14th May 2018

Re: 18/00550/F Stone Walls Bonds End Lane

REVISION	DATE	DRAWN	CHECKED	DESCRIPTION	SCALE	DATE
				CLIENT Mr M Smales	1:200 @ A3	December 2014
				PROJECT Stonewalls, Bond End Lane, Sibford Gower, OX15 5RT	DRAWN MH	CHECKED MH
				DRAWING TITLE Site Layout Plan As Proposed	JOB NUMBER <b>1306</b>	DRAWING NO. <b>15</b>
						REVISION <b>A</b>

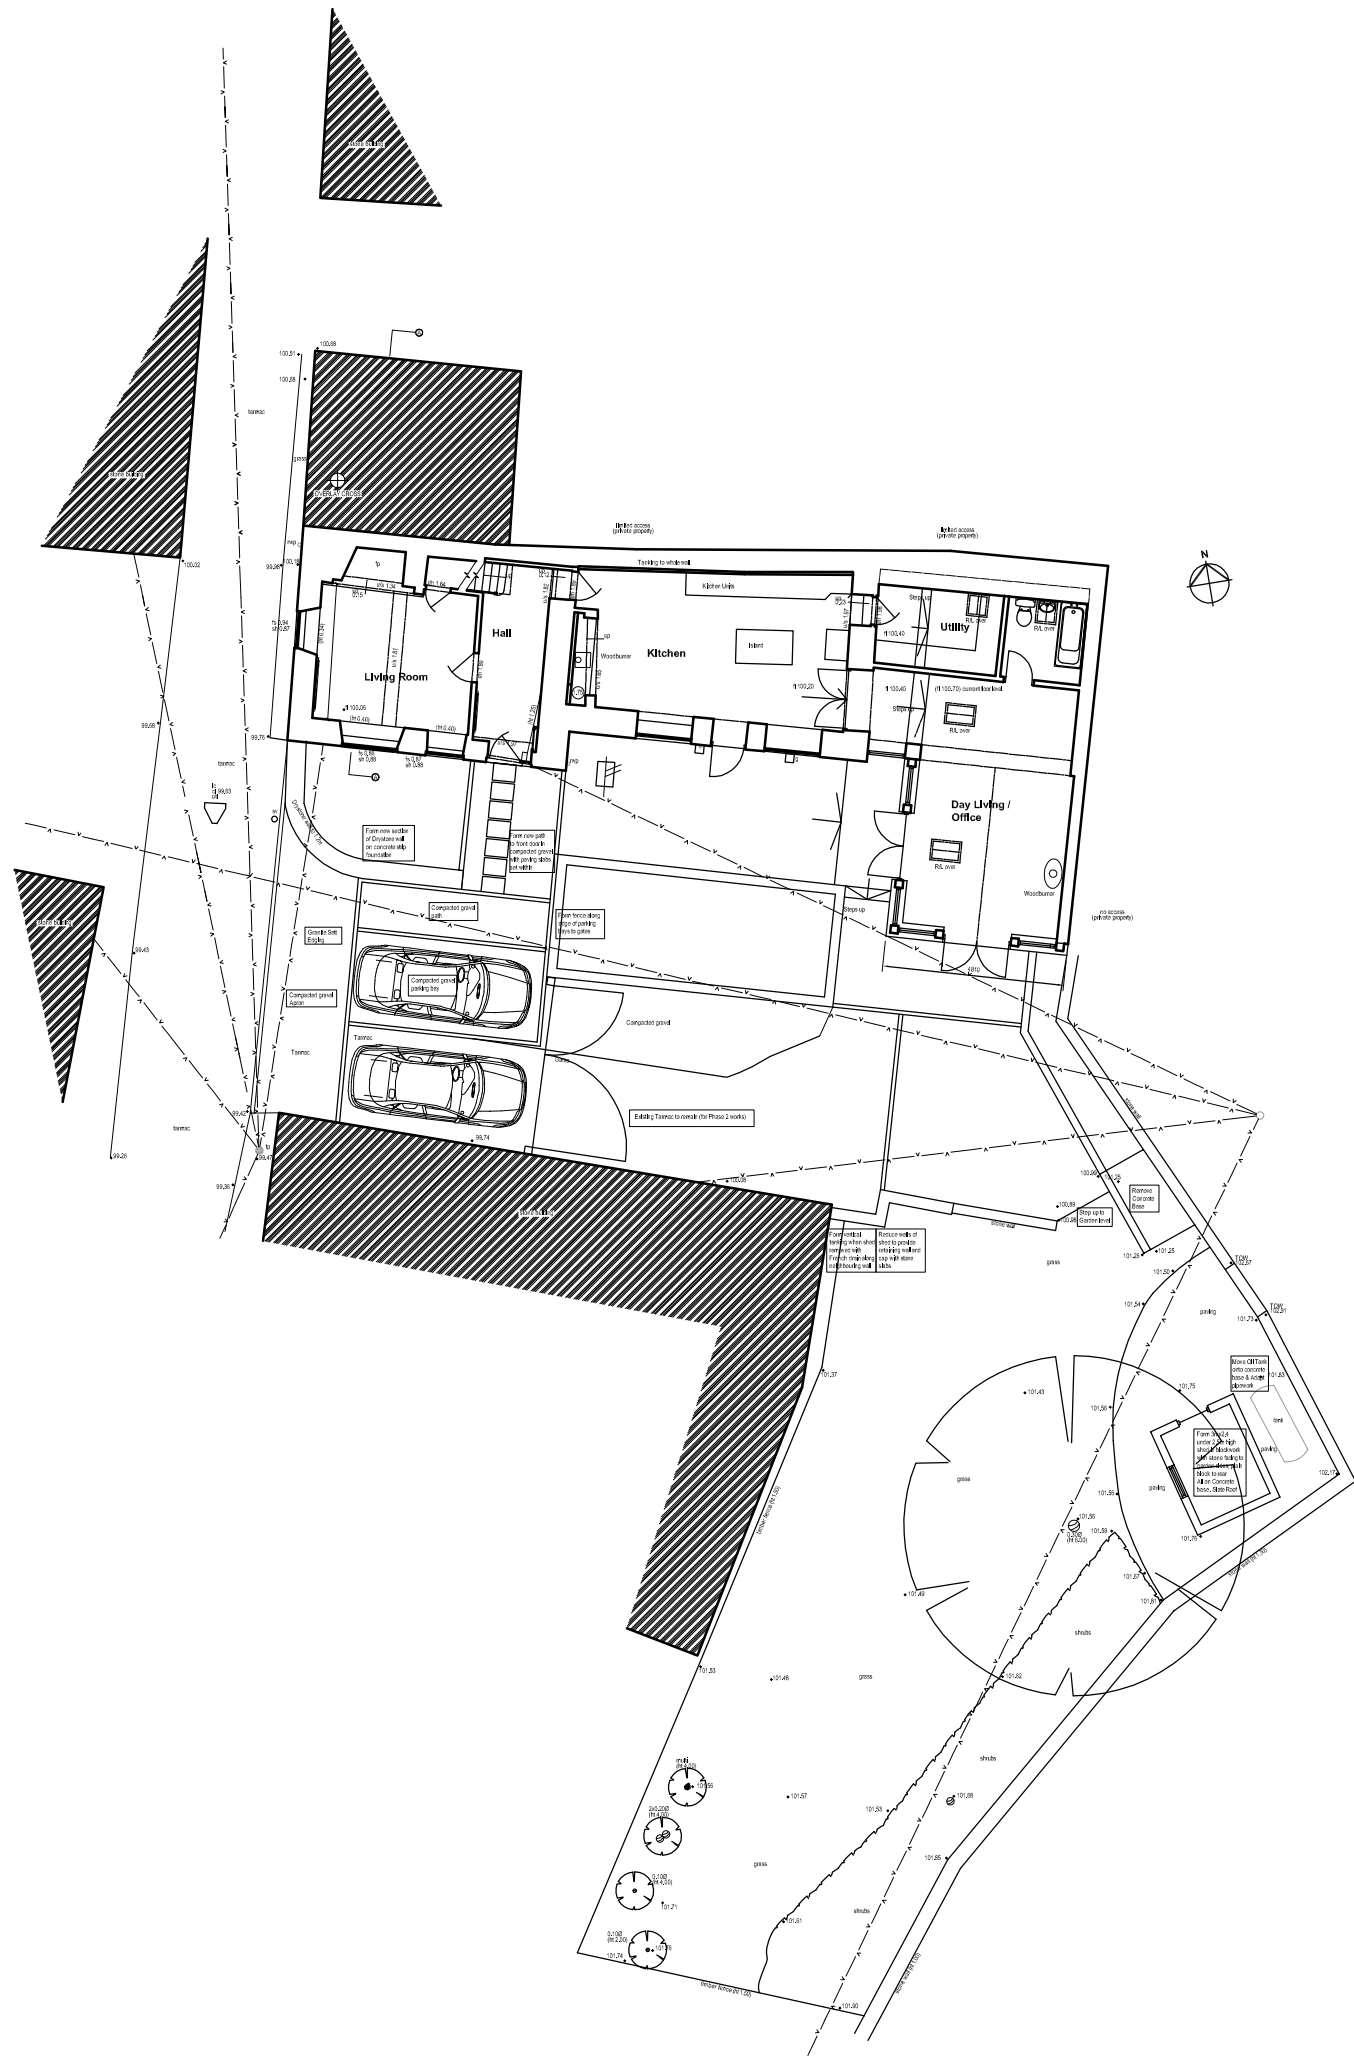
We don't object to the project in principle, our concern is about the stability of the retaining wall, this is holding back some 2000mm of soil. We feel the retaining wall should be left intact, removing or rebuilding this will affect the very mature and large holly hedge next to it by drying out the land and risking claps.

CLIENT	Mr M Smales	SCALE	1:100 @ A3	DATE	December 2014
PROJECT	Stonewalls, Bond End Lane, Sibford Gower, OX15 5RT	DRAWN	MH	CHECKED	MH
DRAWING TITLE	Elevations	JOB NUMBER	1306	DRAWING NO.	14
	As Proposed Option 3			REVISION	C

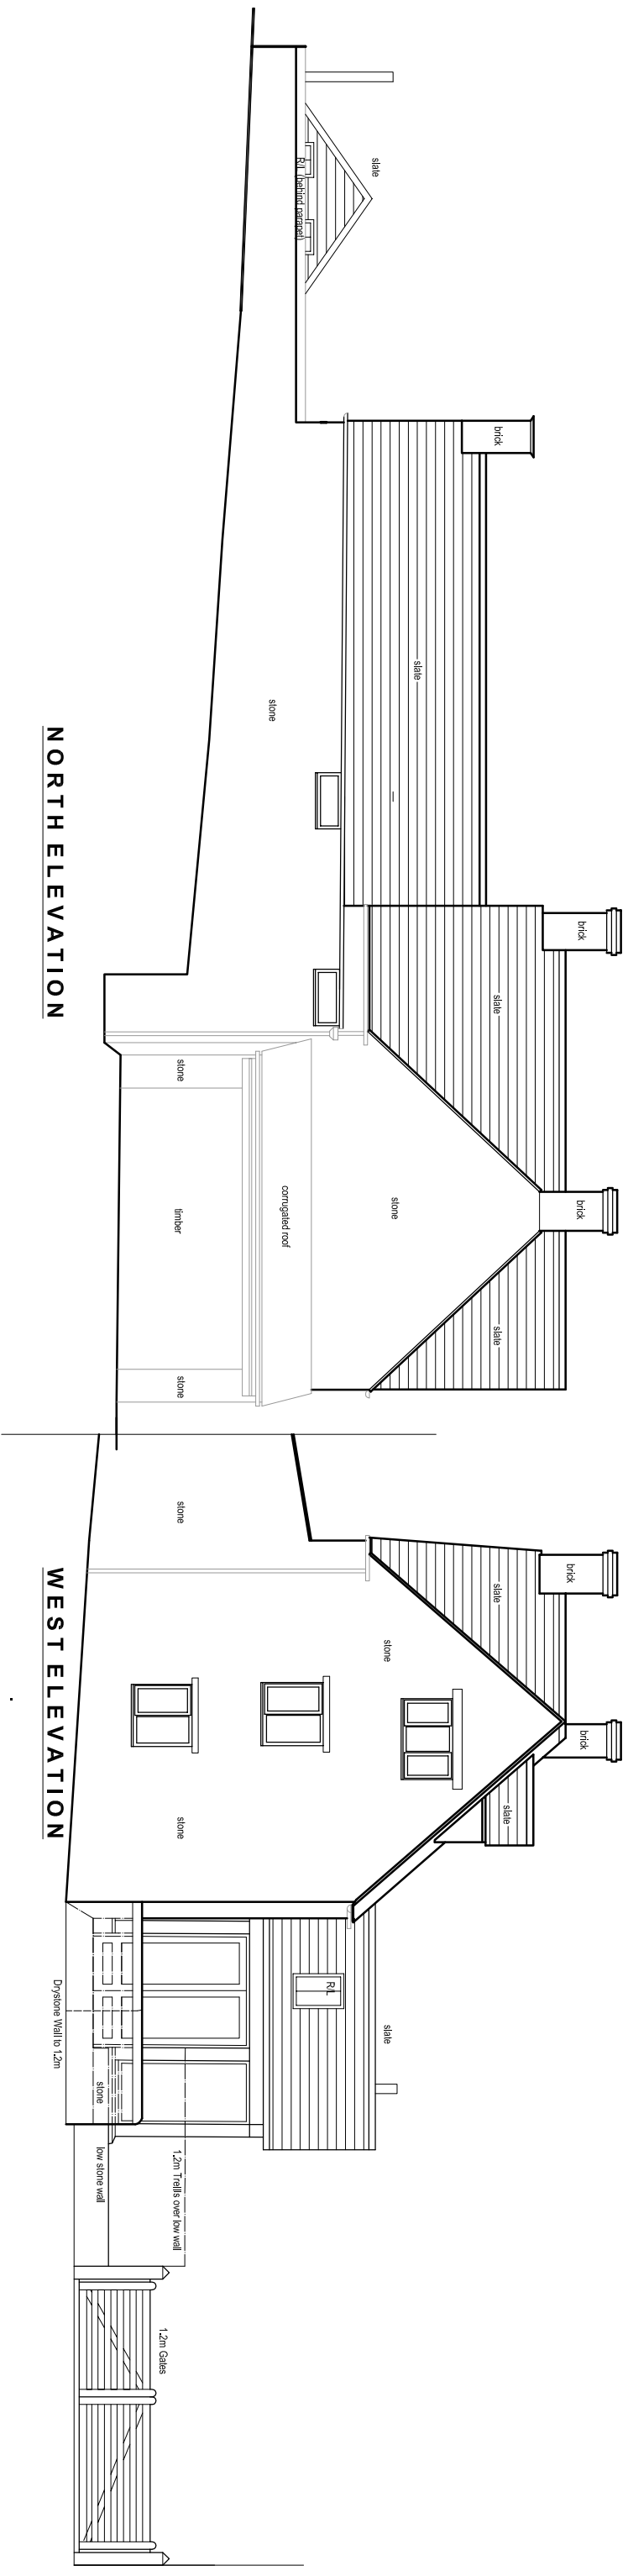
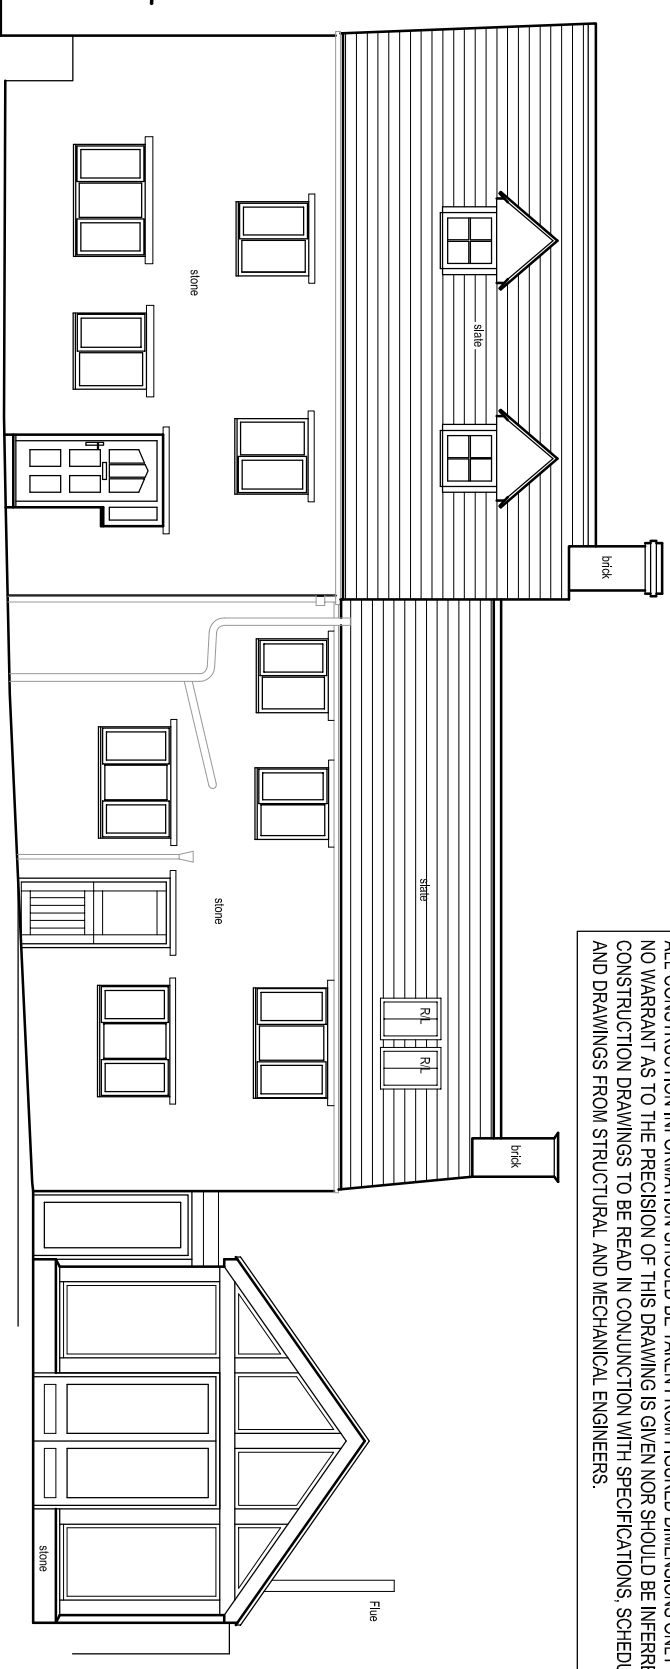
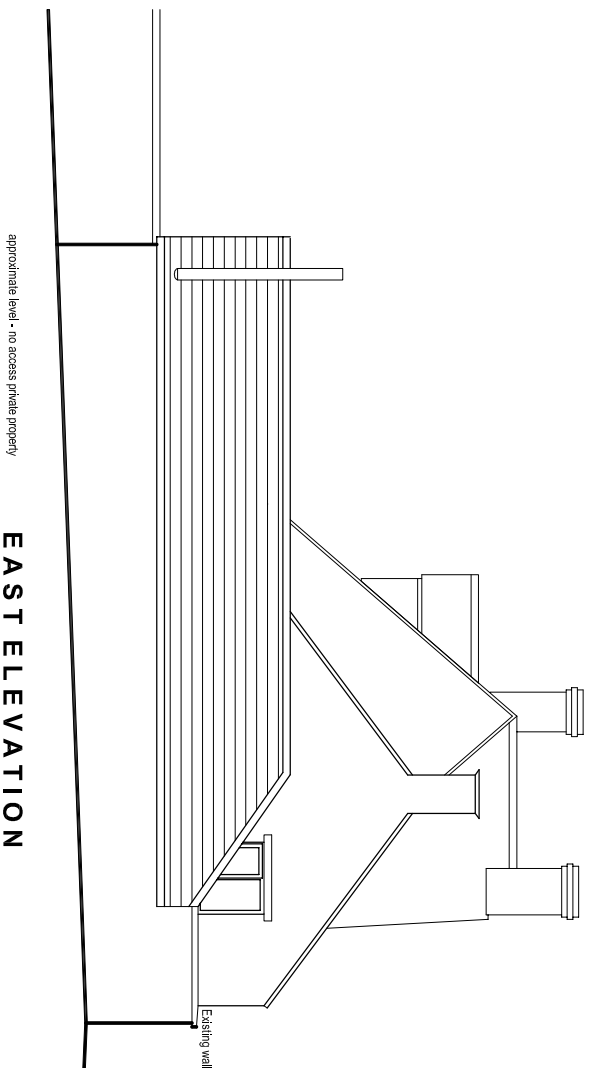
The other concern is the positioning of the flue for the wood burning stove, this is next to a mature holly hedge the top of the flue although appearing high is still below the top of the hedge. We believe that this poses a fire risk as holly is very combustible in the proximity of heat and sparks. If this was repositioned to the other side of the room it could be supported with the gable wall of the house and would remove the risk of fire.
